Subject: Broken Hill Battery Energy Storage (BESS), Modification 1 (SSD-11437498-MOD-1)

BCD has reviewed the supplied Modification Report and associated Biodiversity Development Assessment Report (BDAR).

ATTACHMENT A – BCD comments on Broken Hill Battery Energy Storage – Modification 1 (BESS) (SSD-11437498-Mod-1)

Attachment A – BCD comments on Broken Hill Battery Energy Storage – Modification 1 (BESS) (SSD-11437498-Mod-1)

Vegetation zones and plot locations
Broken Hill Battery Storage BDAR

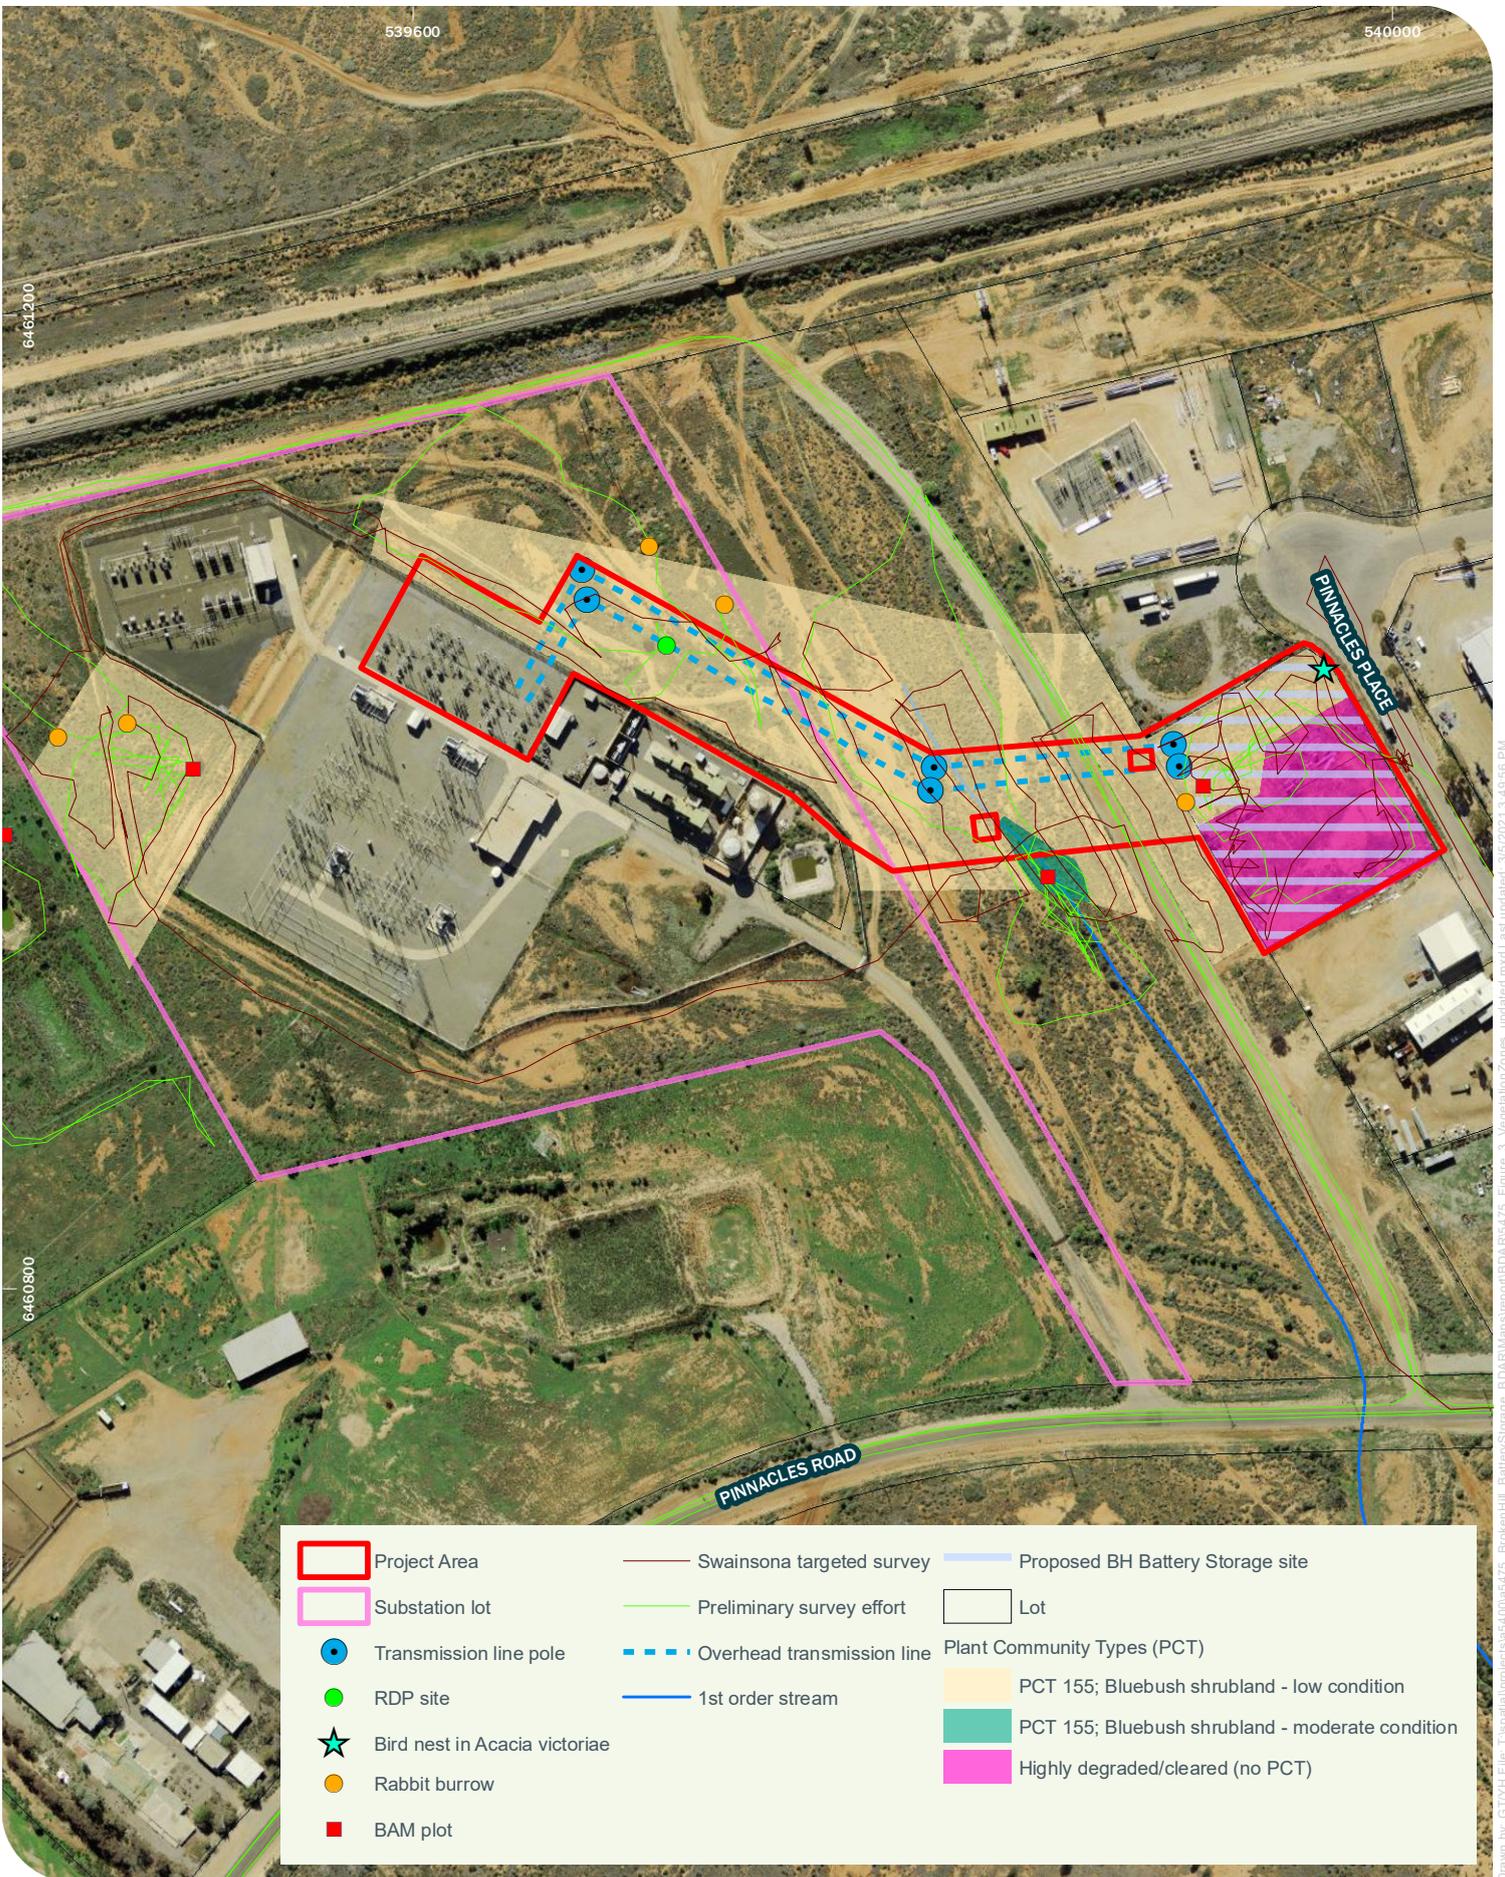
- S3.1.2 is inadequate for justifying why there are no plots in vegetation zone 1 in the modification area. Unclear why additional plots were not sampled in the disturbance footprint (veg zone 1) for the modification when it was raised as an issue for the original project. Figure 3 is confusing and does not demonstrate that threatened flora surveys were adequate.

- Vegetation zones must be clearly identified and mapped in the BDAR and sampled by the minimum number of vegetation integrity plots. Vegetation zoning needs a separate section in the BDAR. There is no map of vegetation zones. No spatial data. Table 7 does not indicate zones as per BAM-C ID#. No vegetation zone for the Battery Site but it is included in the offset summary in s5.3.
